Flood Management & Drainage Consultation

Consultation on Application Number: 2016/92812

Address: Victoria Works, Fisher Green, Honley, Holmfirth, HD9 6DP

Proposal: Demolition of industrial building and erection of 17 No. apartments with integral garages and associated parking

Drainage Layout

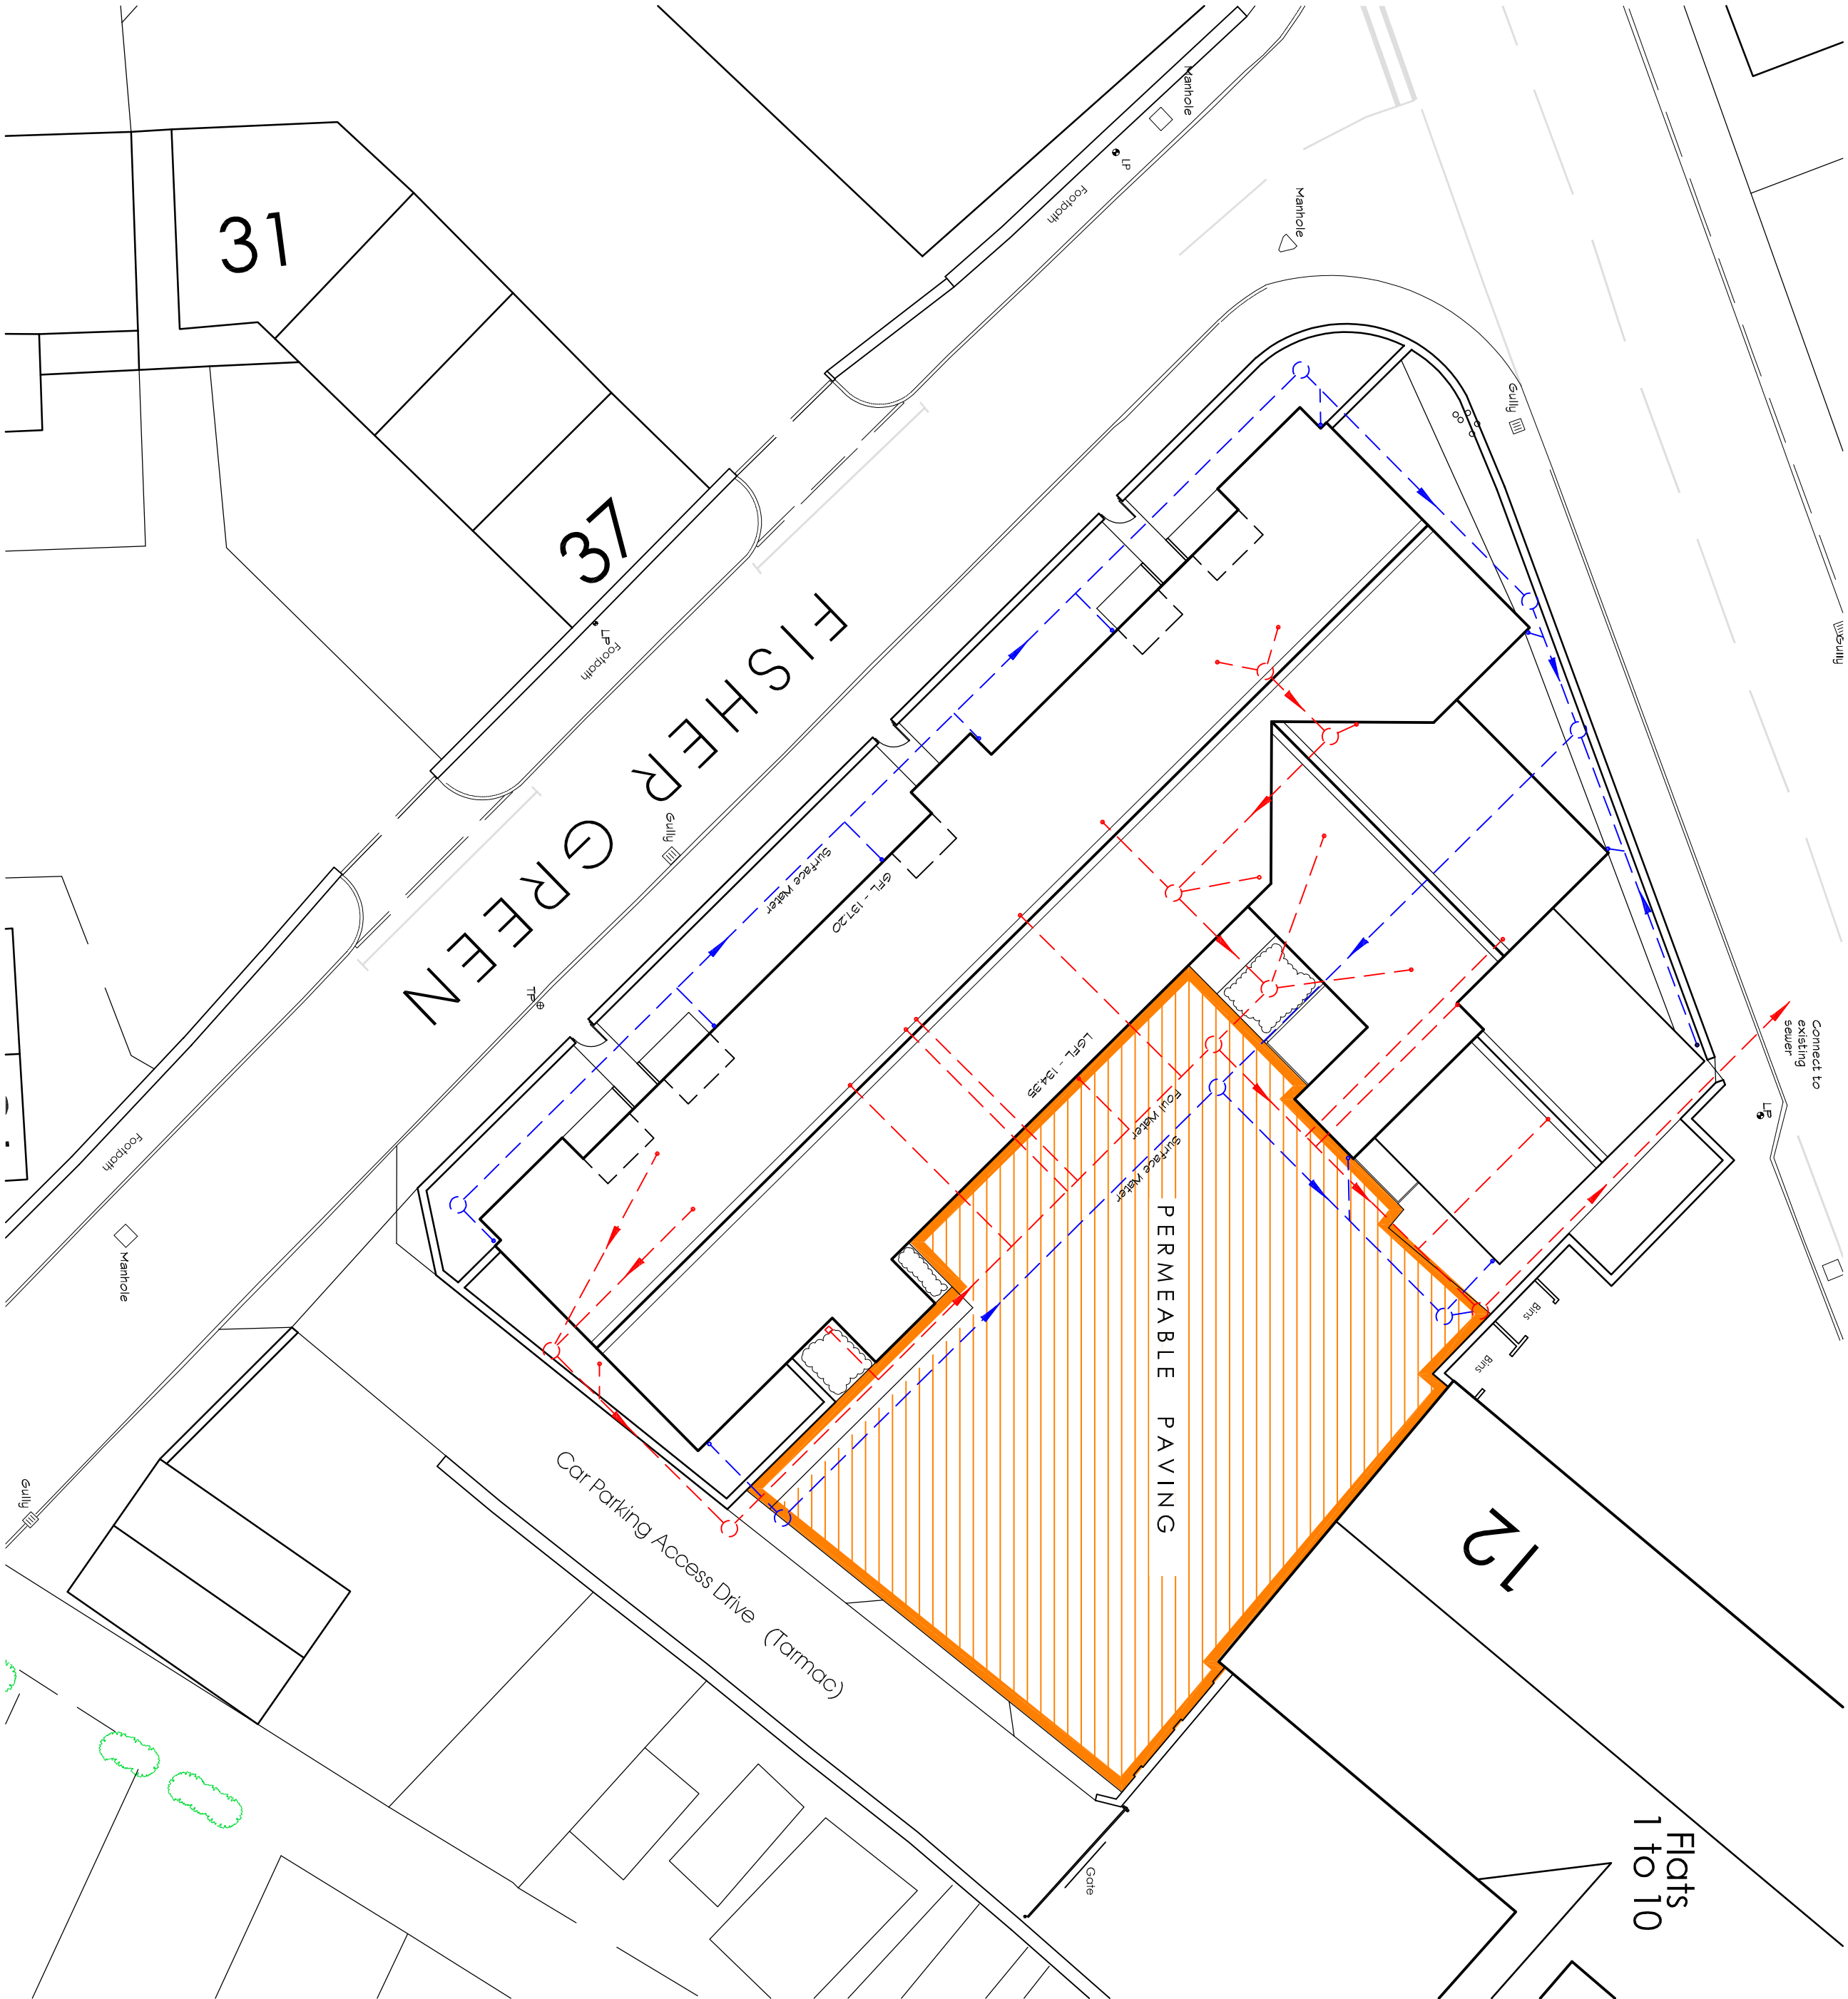
Kirklees Flood Management & Drainage welcomes the additional assessment. However we require evidence that the existing culvert verified to exist downstream, will not be built over by the new development or an acceptable diversion can be agreed with appropriate consent from the Lead Local Flood Authority.

A connection to watercourse can be agreed at an appropriate rate to be determined. Attenuation can be accommodated and the detailed design can be conditioned using Kirklees standard drainage conditions.

Existing watercourses should not be built over and should have appropriate stand-off distances. This aspect will need to be determined prior to approving layout design.
